KIRKLEES METROPOLITAN COUNCIL INVESTMENT & REGENERATION SERVICE

DELEGATED DECISION TO DETERMINE APPLICATIONS FOR LISTED BUILDING CONSENT

Reference No:	2024/65/93504/W
Site Address:	New Hagg Barn, Oldfield Road, Honley, Holmfirth, HD9 6RN
Description:	Listed Building Consent for Installation of an air source heat pump, enlargement of existing window, new external timber decking and conservation roof lights
Recommending Officer:	Joanna Rednall

Drawing Title
PROPOSED ROOF PLAN

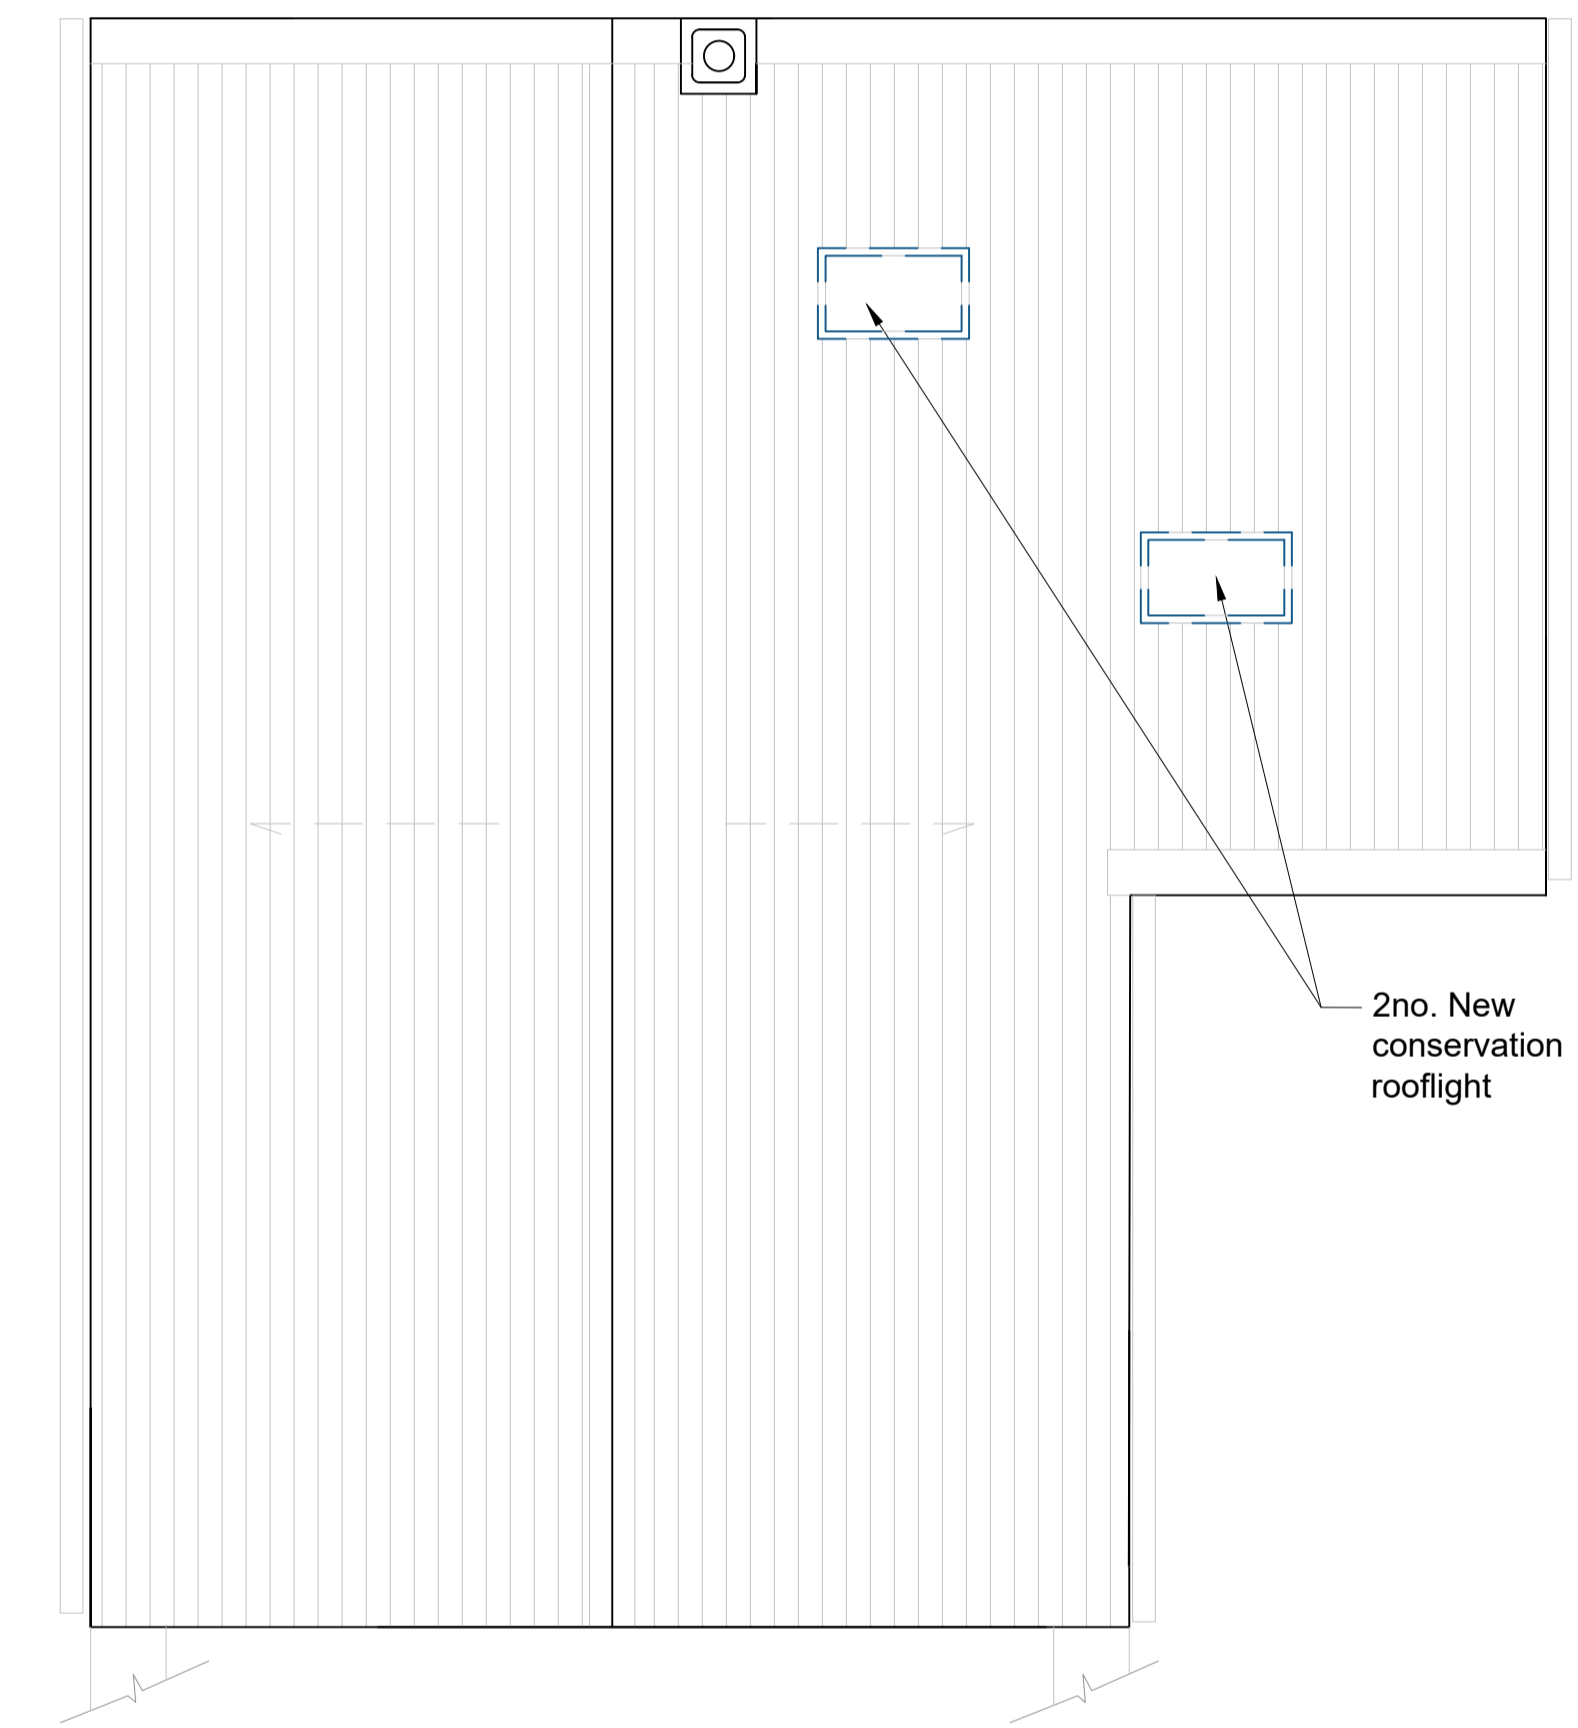
The air source heat pump is modest in scale and would be discreetly positioned on the east-facing elevation, while the conservation rooflights are limited in number and their detailed design can be appropriately controlled by condition. The air source heat pump would be located on a secondary, rear elevation and would not be visible from public vantage points. Although the unit would be finished in white, it would not be positioned on a principal elevation and would therefore not detract from the historic interest or legibility of the building or its setting.

Drawing Title
PROPOSED GROUND FLOOR DEMOLITION AND PLAN

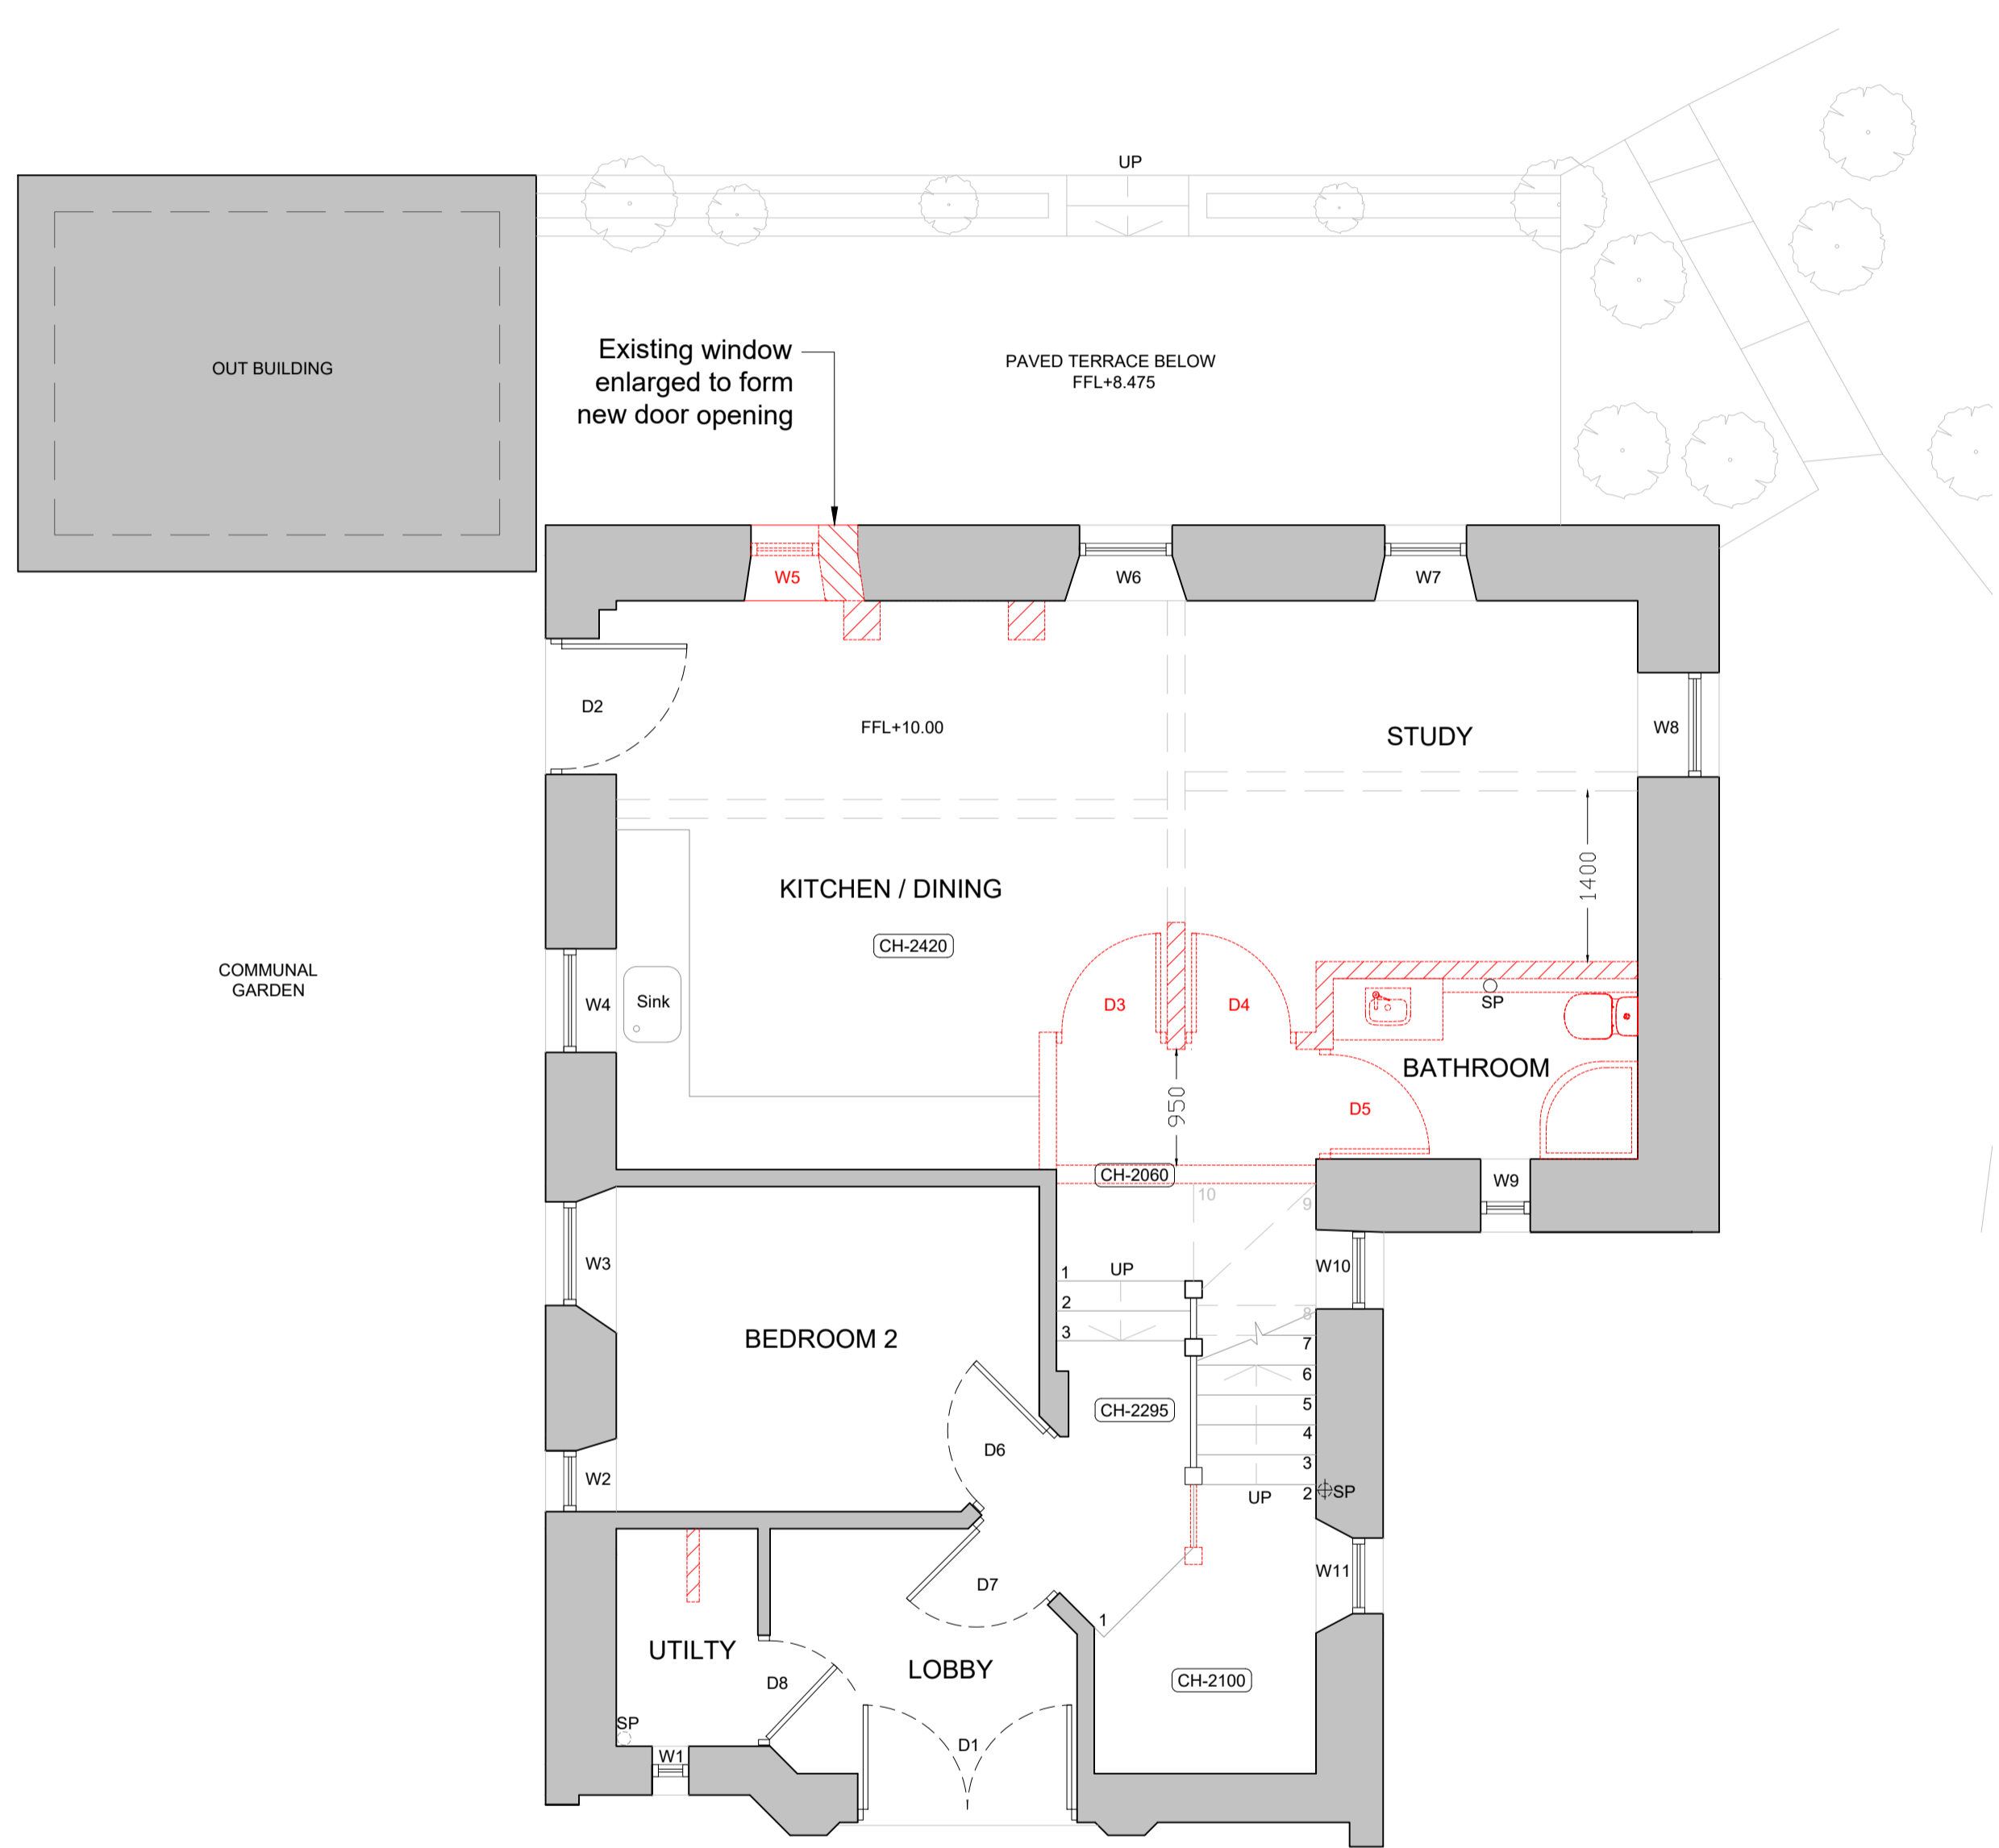
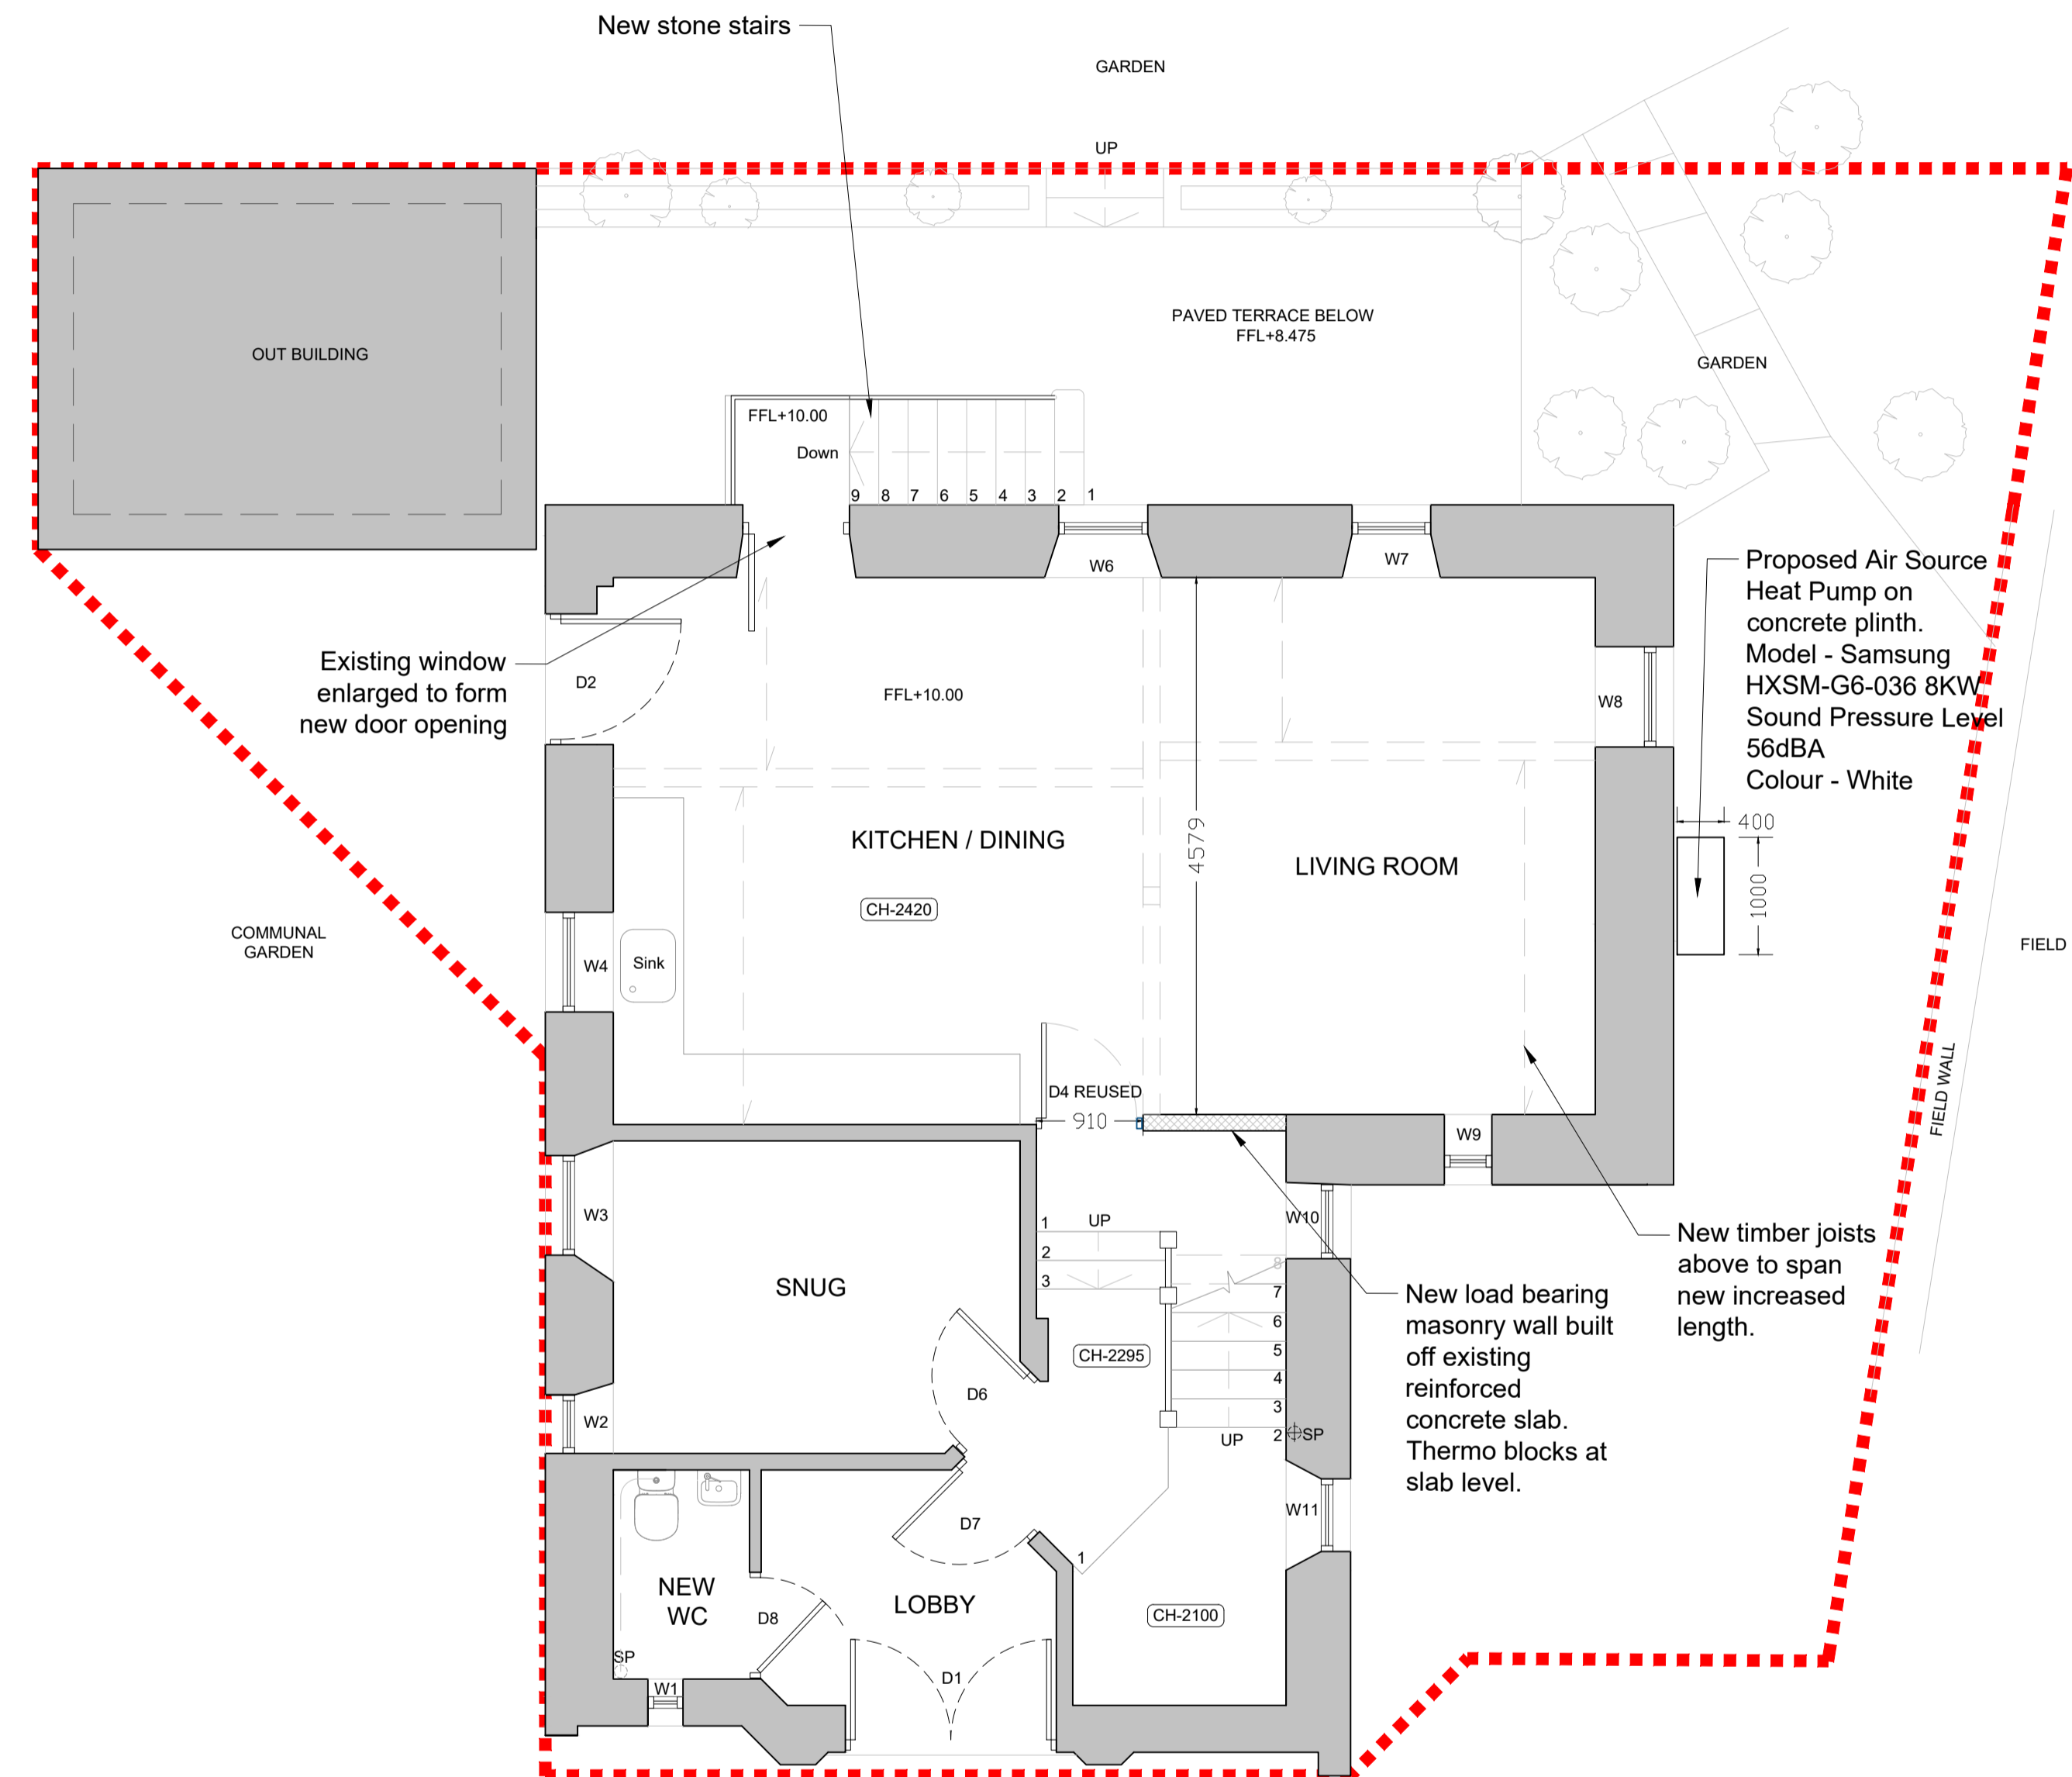
Amendments were sought to reduce the scale of the raised decking in response to the comments from the Council's Conservation and Design Officer. Amended plans were received 28th March 2025 which were deemed acceptable and the application has progressed on this basis. The amended plans were not re-publicised as these did not fundamentally change the development applied for.

KC Conservation and Design: There is no objection to the proposed air source heat pump or rooflights. However, officers raised concerns regarding the extent of the originally proposed decking, as it would have introduced excessive residential paraphernalia that was inconsistent with the character of the former barn and would have detracted from its historic interest. The extent of decking has since been reduced, and officers consider the revised plans to be more acceptable.
